## Planning Inspectorate

Application by RWE Renewables UK Dogger Bank South (West) Ltd and RWE Renewables UK Dogger Bank South (East) Ltd for an Order granting Development Consent for the Dogger Bank South Offshore Wind Farms (Ref: EN010125)

Action points arising from Day 1 of the Issue Specific Hearing 2 at 14:00 on 15 January 2025

Title:  
Potential spawning habitat heat map for Atlantic herring in the vicinity of the Dogger Bank South Offshore Windfarms overlaid with contours associated with revised and original monopiling locations. Produced using approaches from Kyle-Henney et al. (2024).

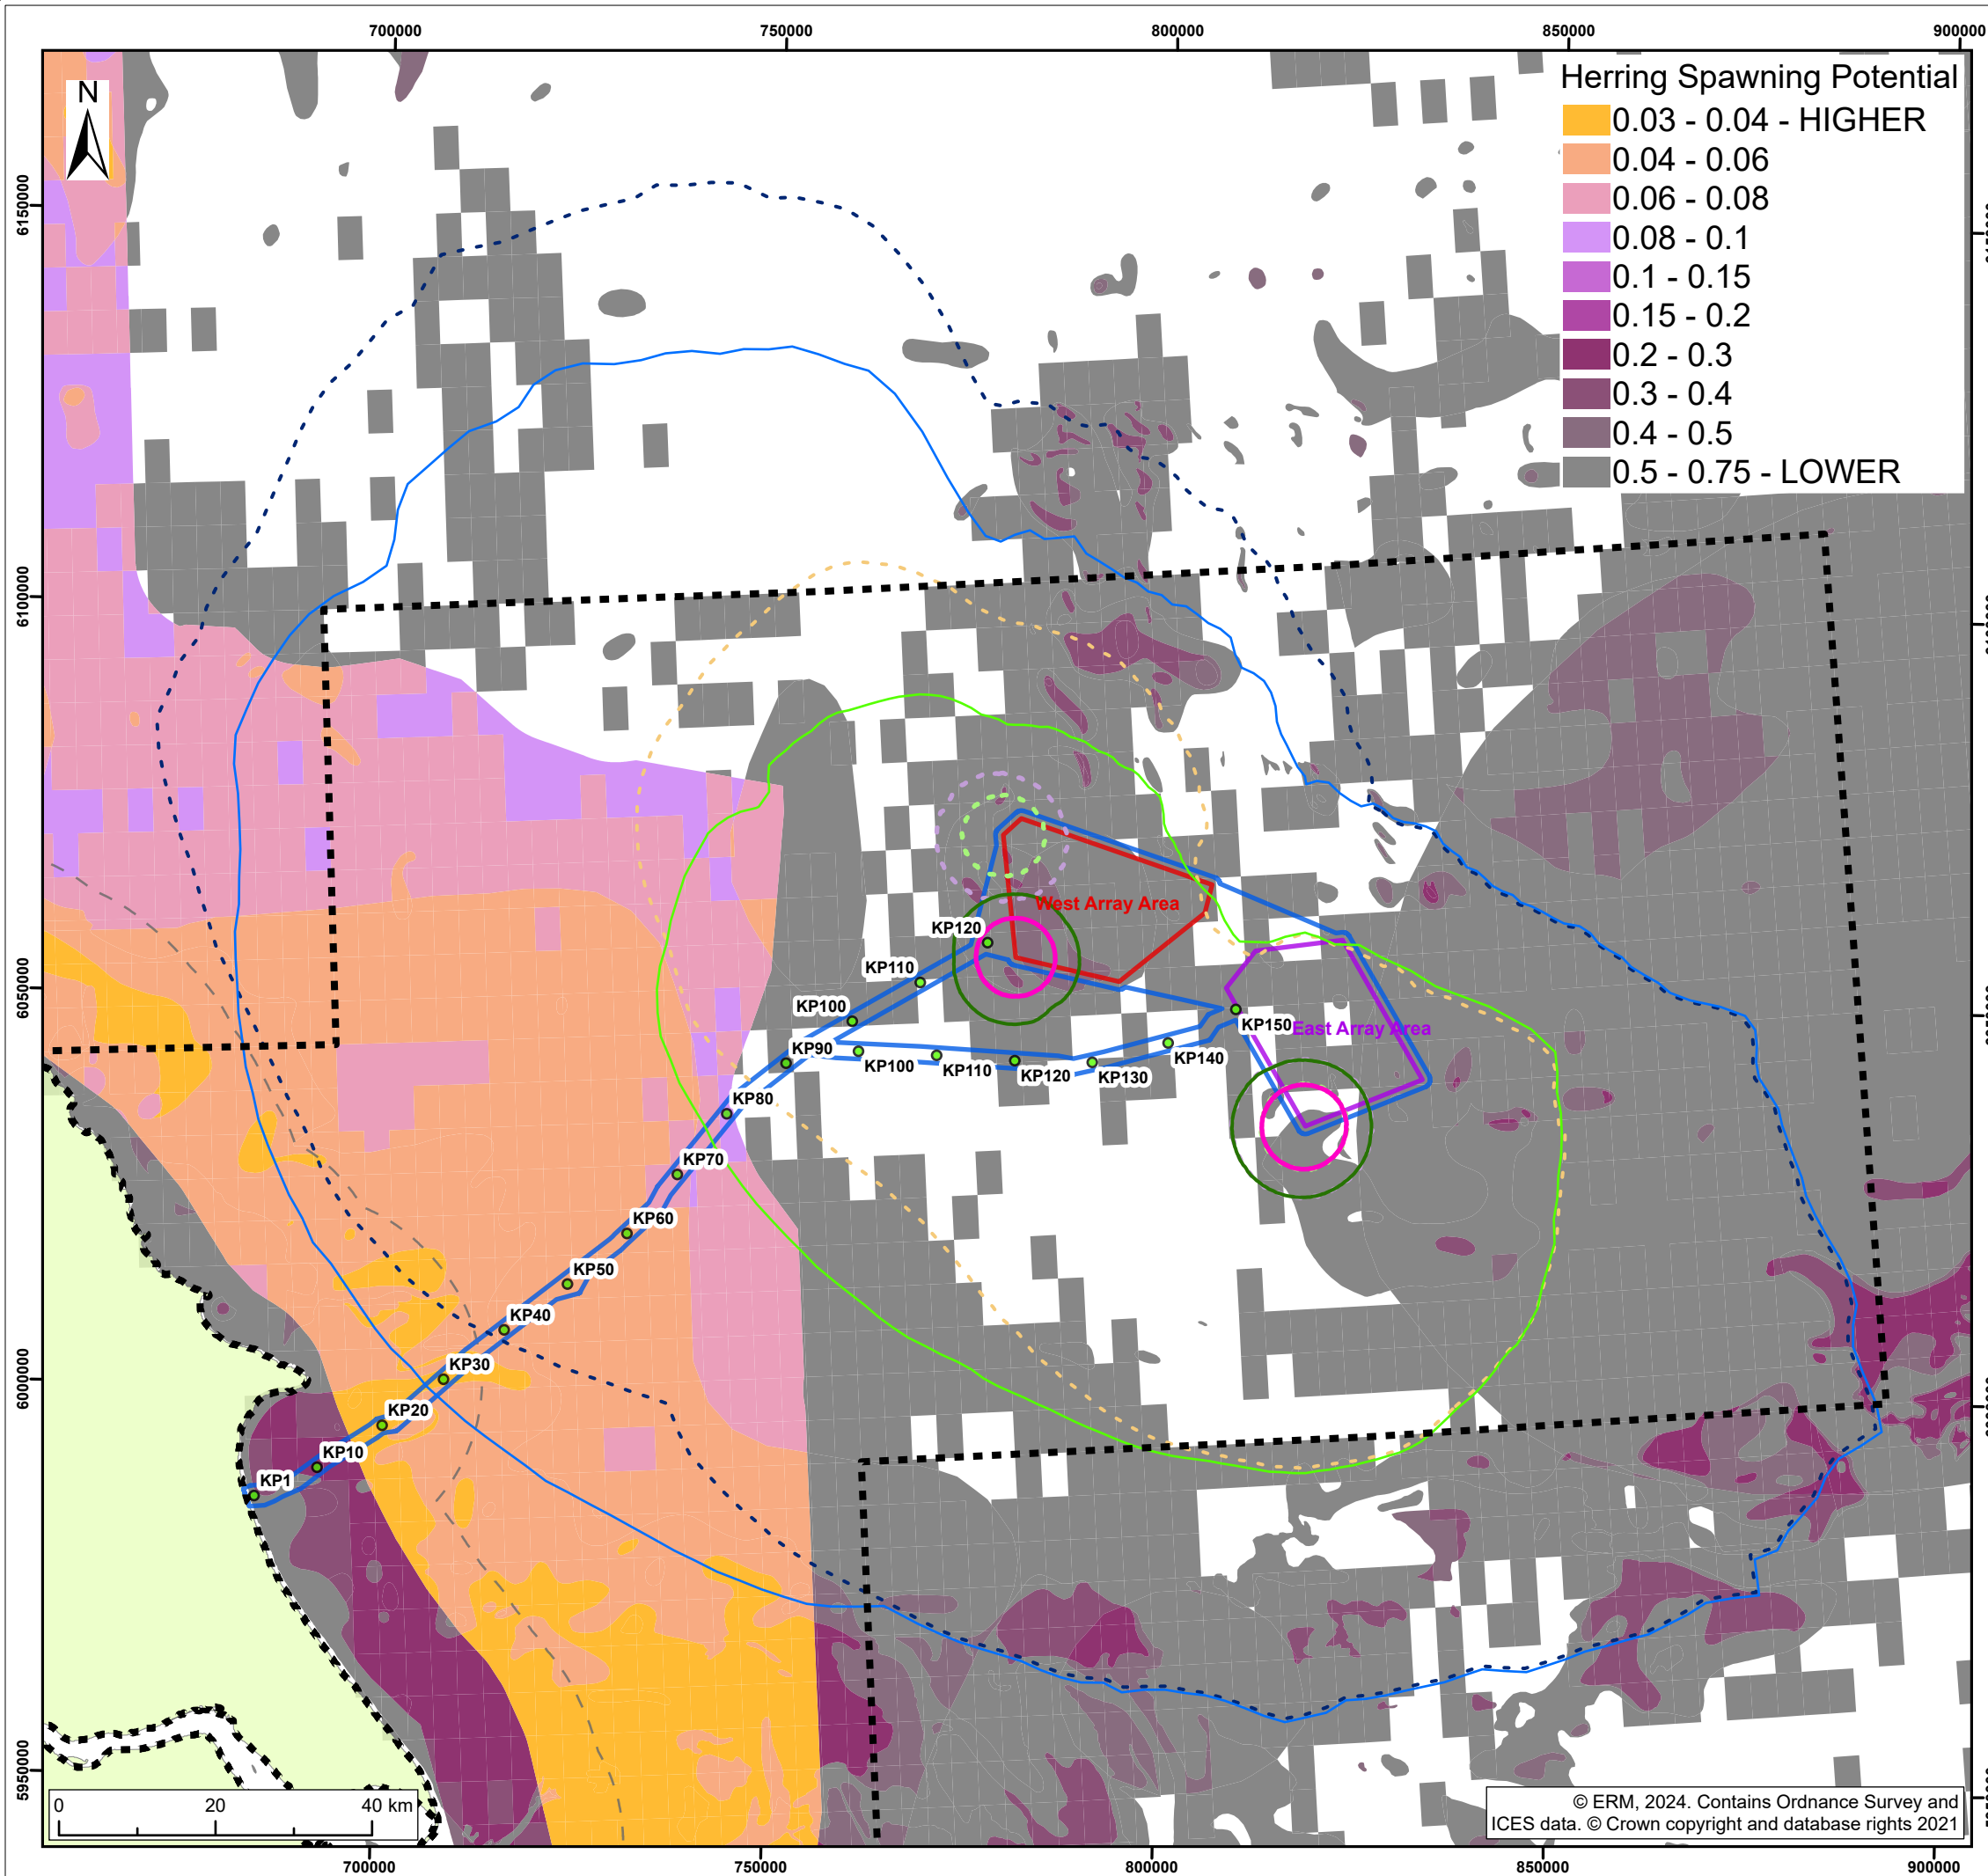
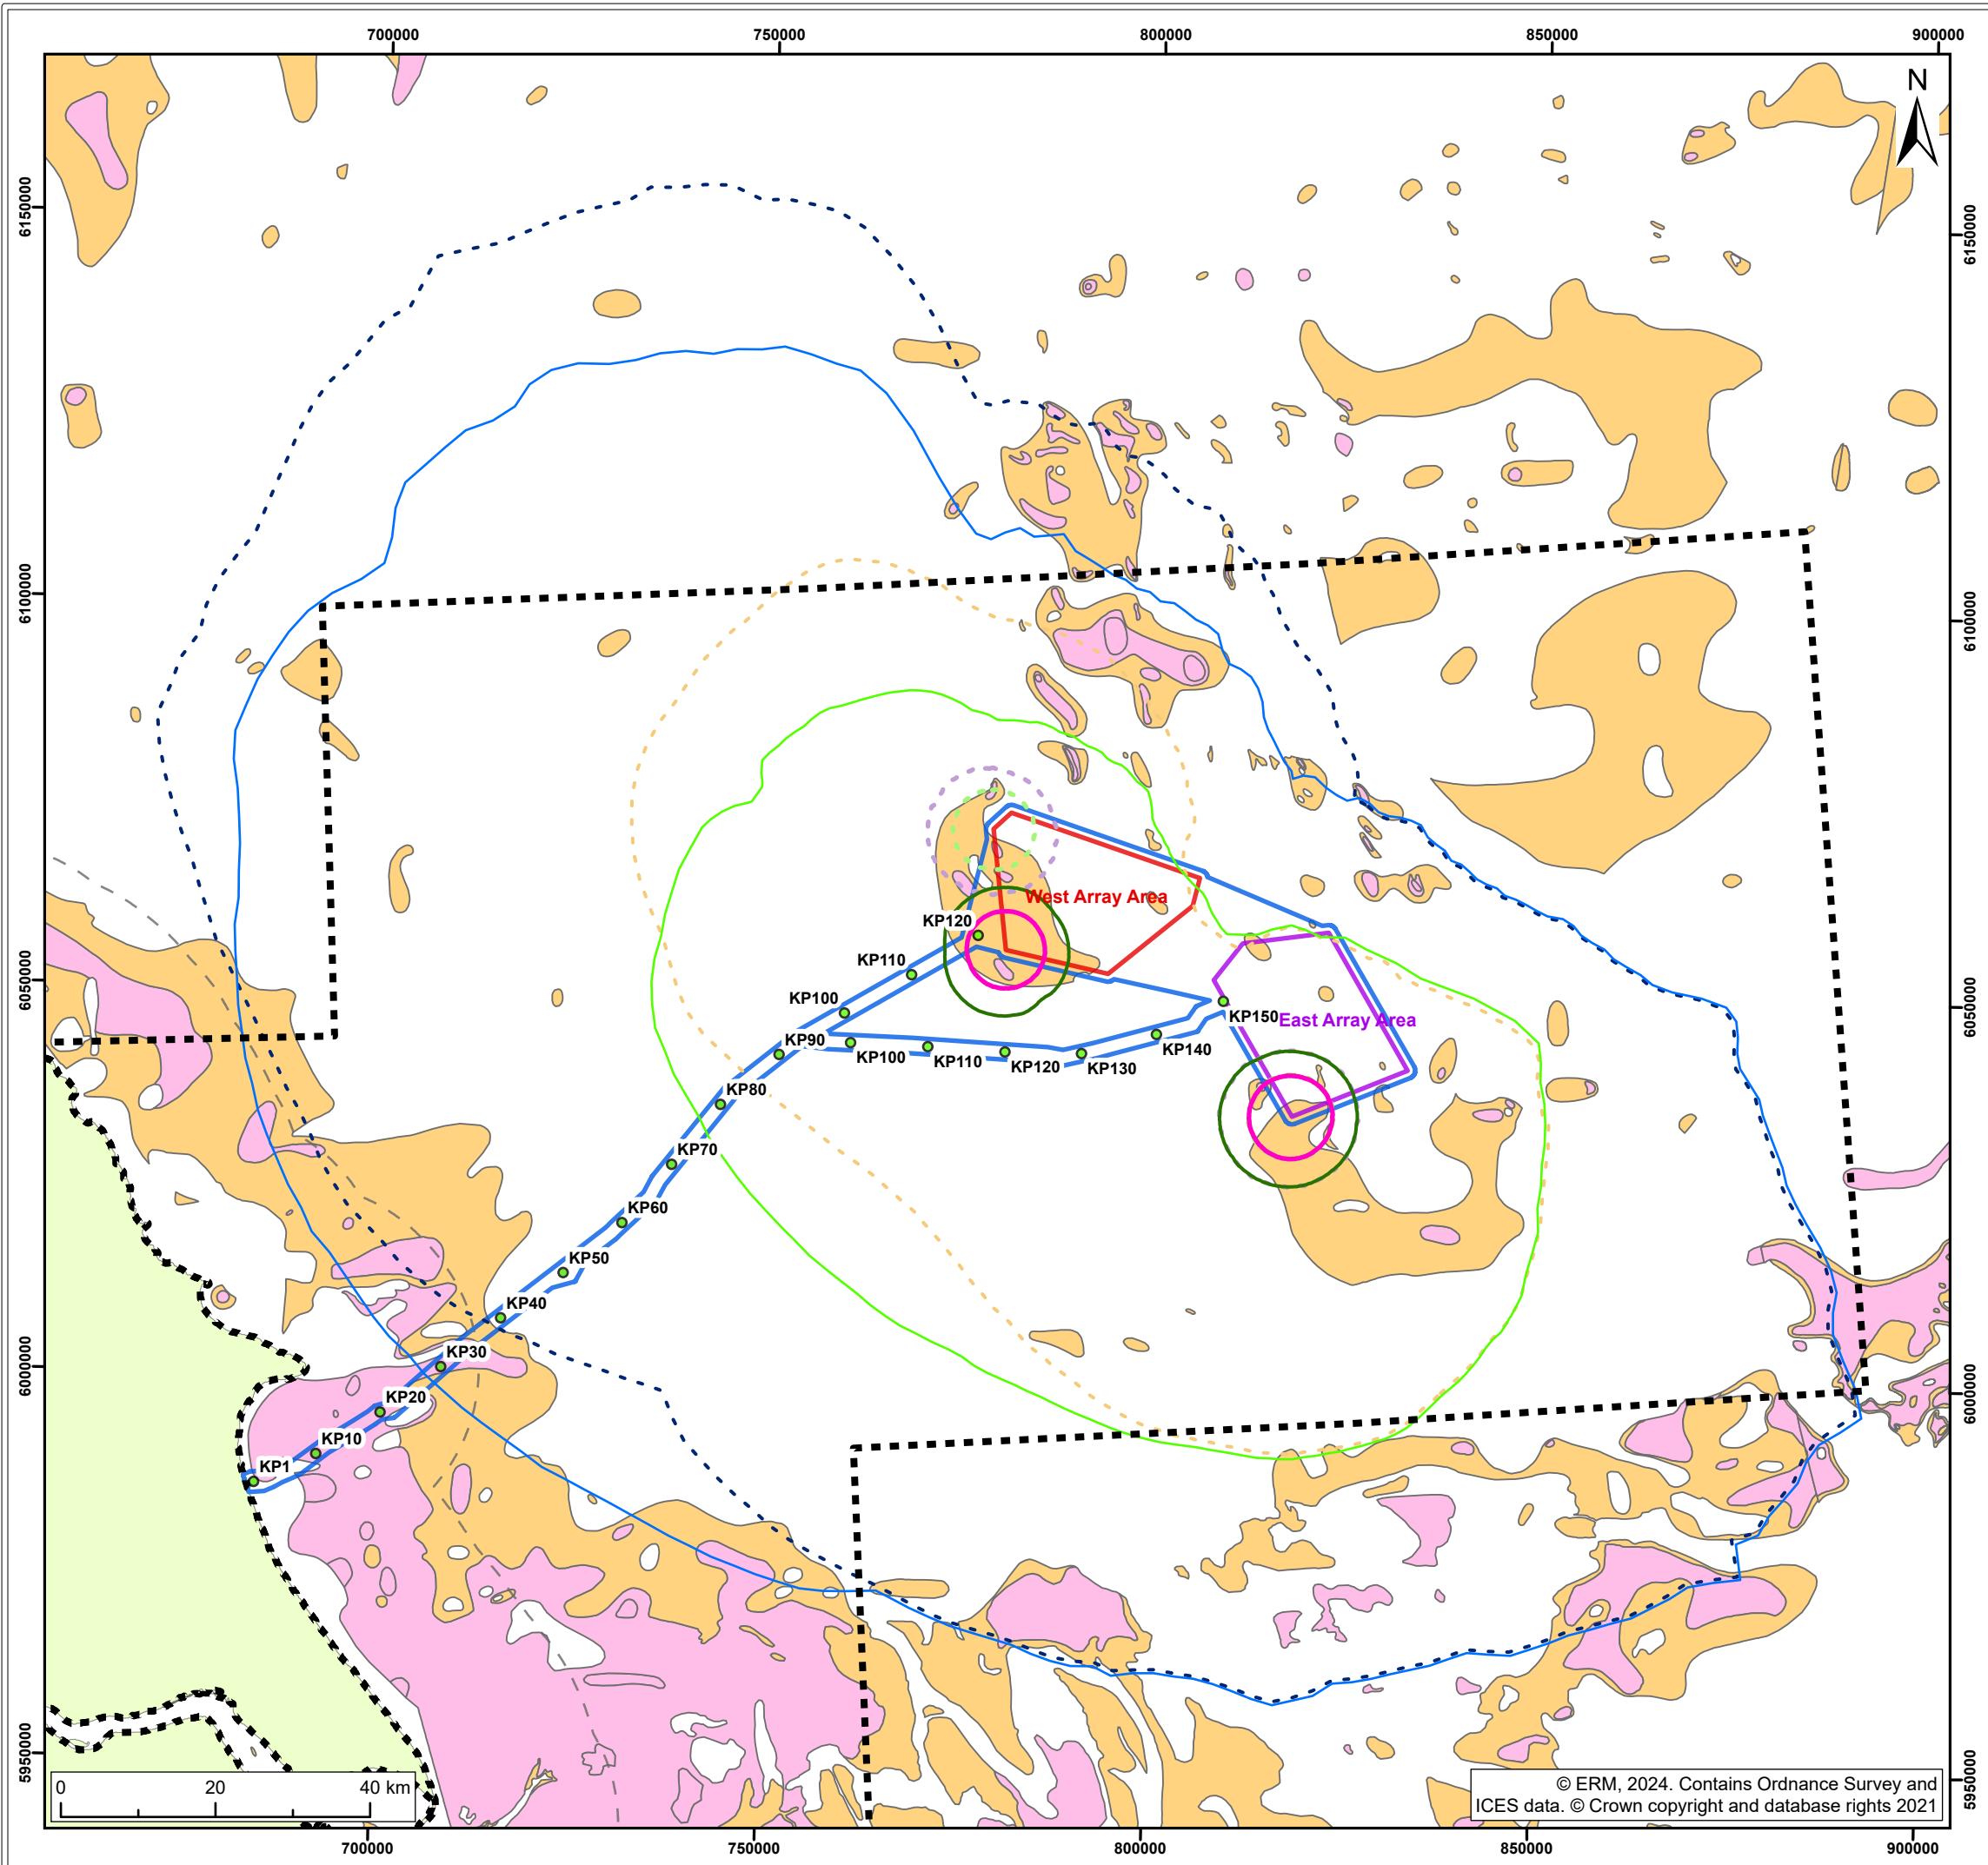
34	The Applicants	Natural England <a href="#">[RR-039]</a> stated that the assessment of underwater noise impacts on herring does not use the worst-case location. Provide a response to the suggestion made by the ExA during ISH2 on whether a reassessment based on the most south-westerly point of the proposed DBS West array could result in greater overlap with the ‘high’ and ‘very high’ herring spawning potential habitat and

Action No.	Directed to	Action
		whether this could result in a greater impact outcome? If so, would a reassessment be undertaken and submitted?
35	Natural England and the MMO	Listen to the recording of Issue Specific Hearing 2 for agenda item 8.2 and provide a response to the Applicants' statements on questions asked by the ExA.
